Recommendation Report for Planning Permission for Works or Extension to a Dwelling

REF NO: FG/87/22/HH

LOCATION: 23 Colindale Road North
Ferring
BN12 5LB

PROPOSAL: Single storey side extension.

SIDE (n) ELEVATION 1:100 @ A3

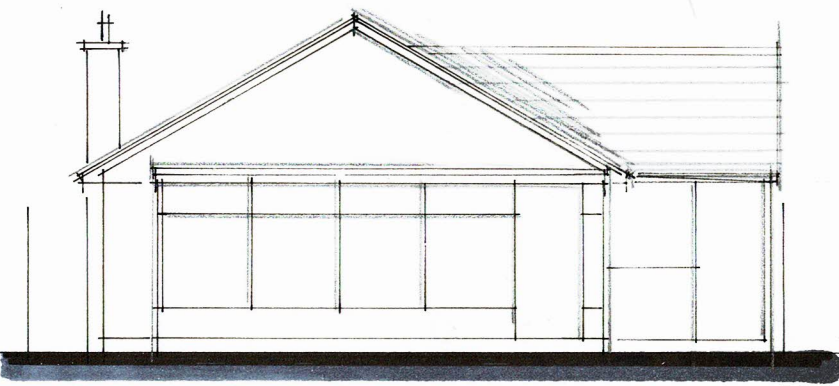
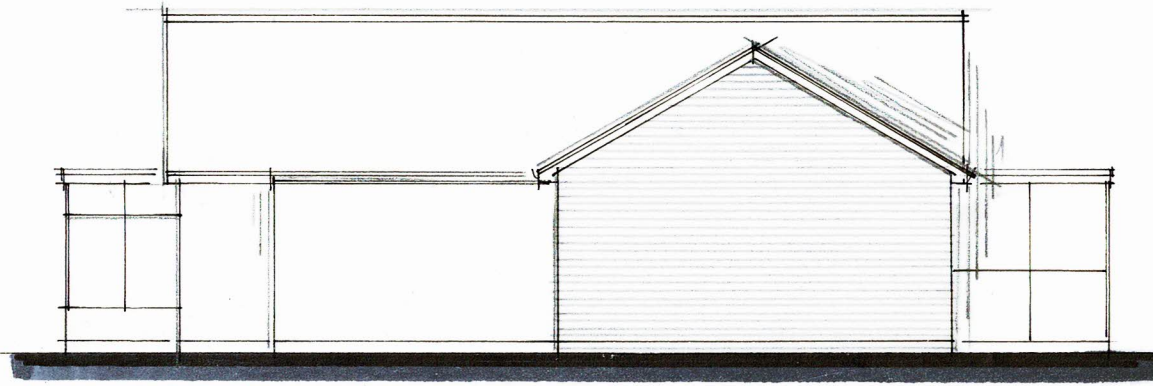
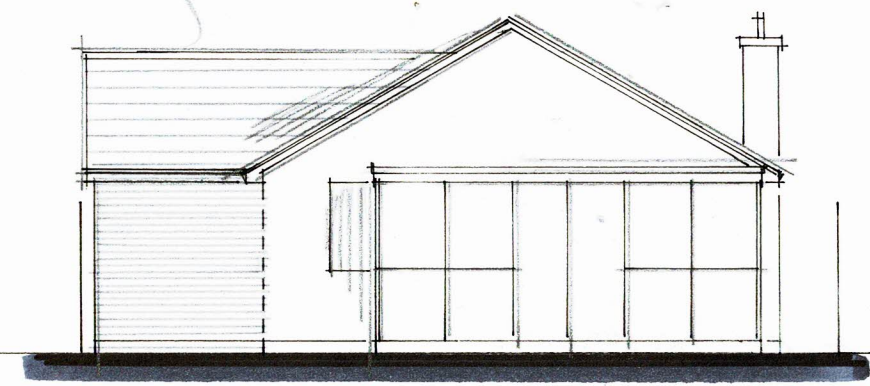
The proposed side extension is to be approx. 2.25m in width, 5.175m in depth, 4m at ridge height and 2.3m at eaves height. The scale is visually subservient to, and well integrated with the host dwelling. The roof design is to sit lower than the existing ridge height and is of a matching pitched design that is orientated perpendicular to the ridge line. Given the orientation of the proposed roof, it would be visible from the front and as such, have a visual impact on the wider street scene.

Given the proposed materials are to match those found on the existing dwelling and that the extension is of an appropriate design, there is no adverse visual impact on the wider street scene.

Drawing no. **FG/CDRN/02**

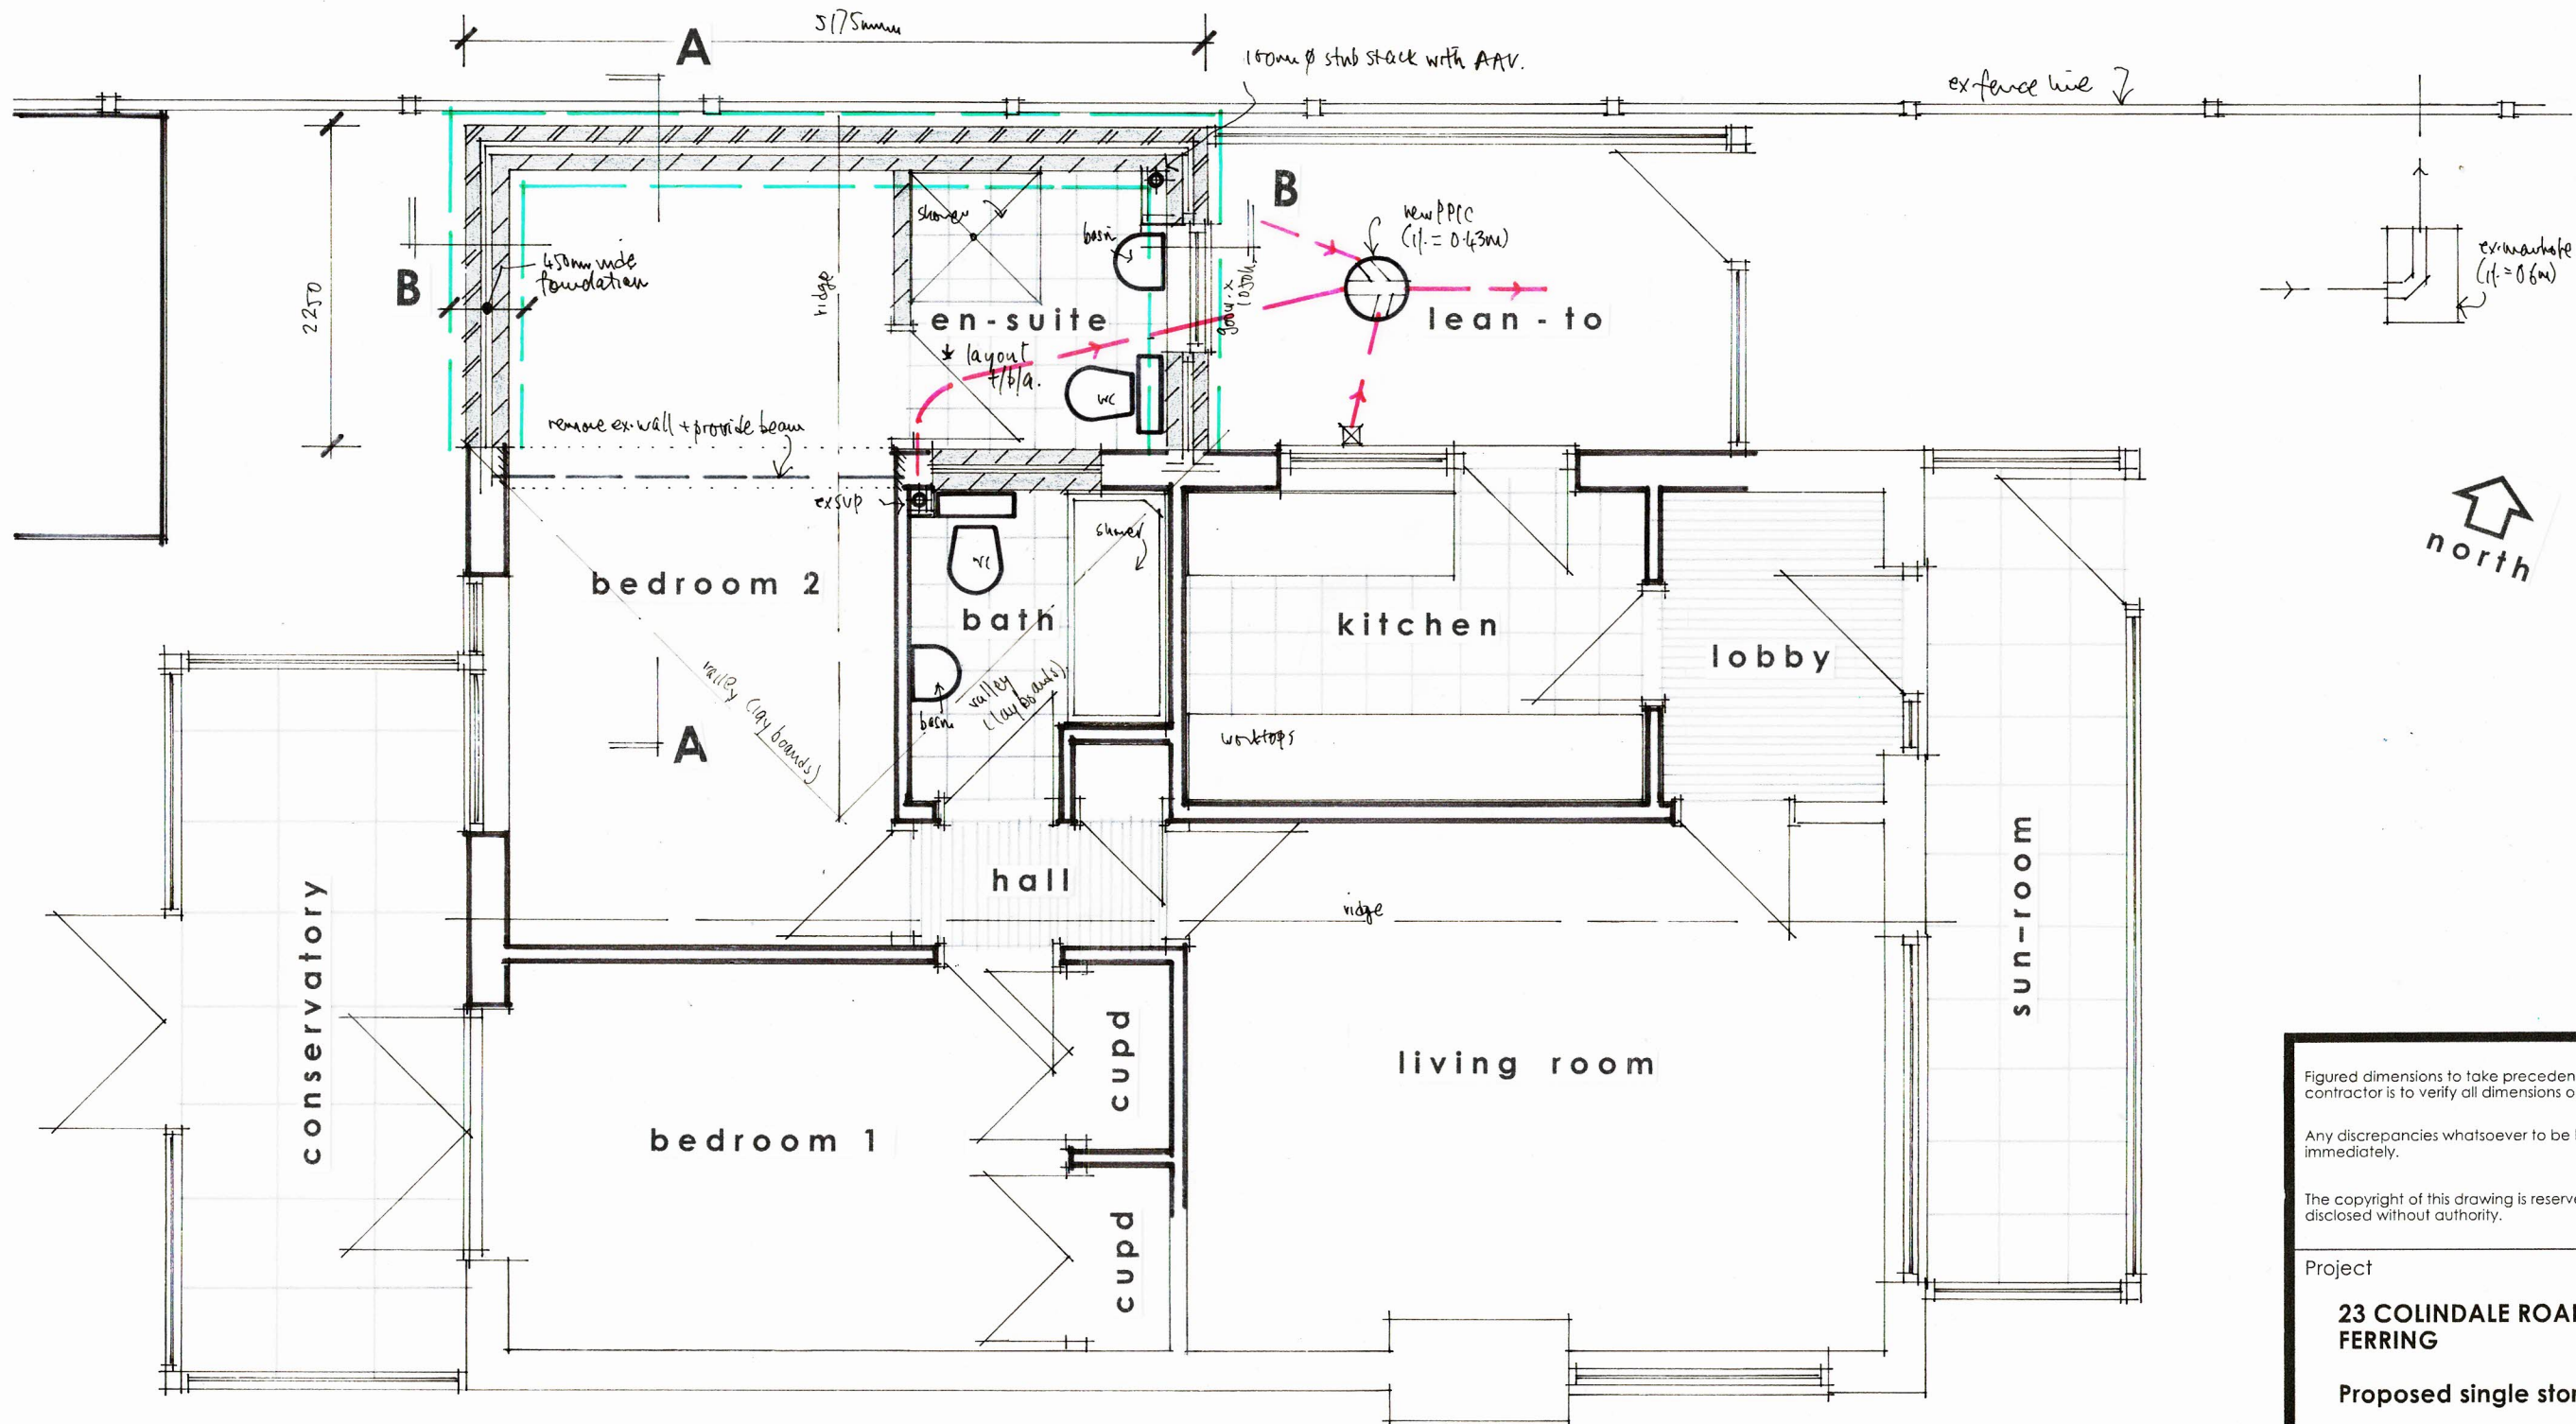
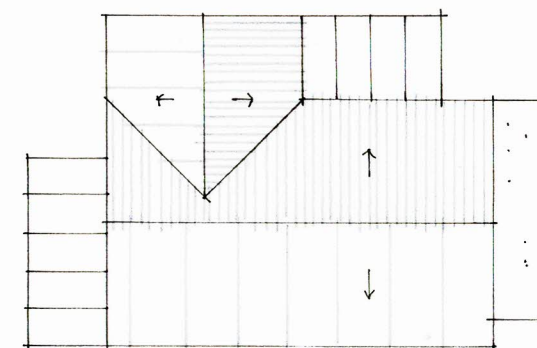
The siting of the extension is such that it almost meets the side (North) site boundary. This is not compliant with the recommended 1m separation distance from side site boundaries set out in Section M of the Arun Design Guide. However, given this extension is single storey at ground floor level and the North neighbouring dwelling remains separated from the shared site boundary by approx. 2.8m where the extension would meet the boundary, this is acceptable.

The proposed side extension is of a siting and scale that would not result in the intersection of any 45-degree light accessibility lines or sightlines. Although the extension meets the site boundary and reaches a peak height of approx. 4m, the siting of the extension remains toward the side elevation of the North neighbour dwelling and does not detract from any amenity viewpoints or adversely impact the rear amenity space of the neighbouring dwelling.
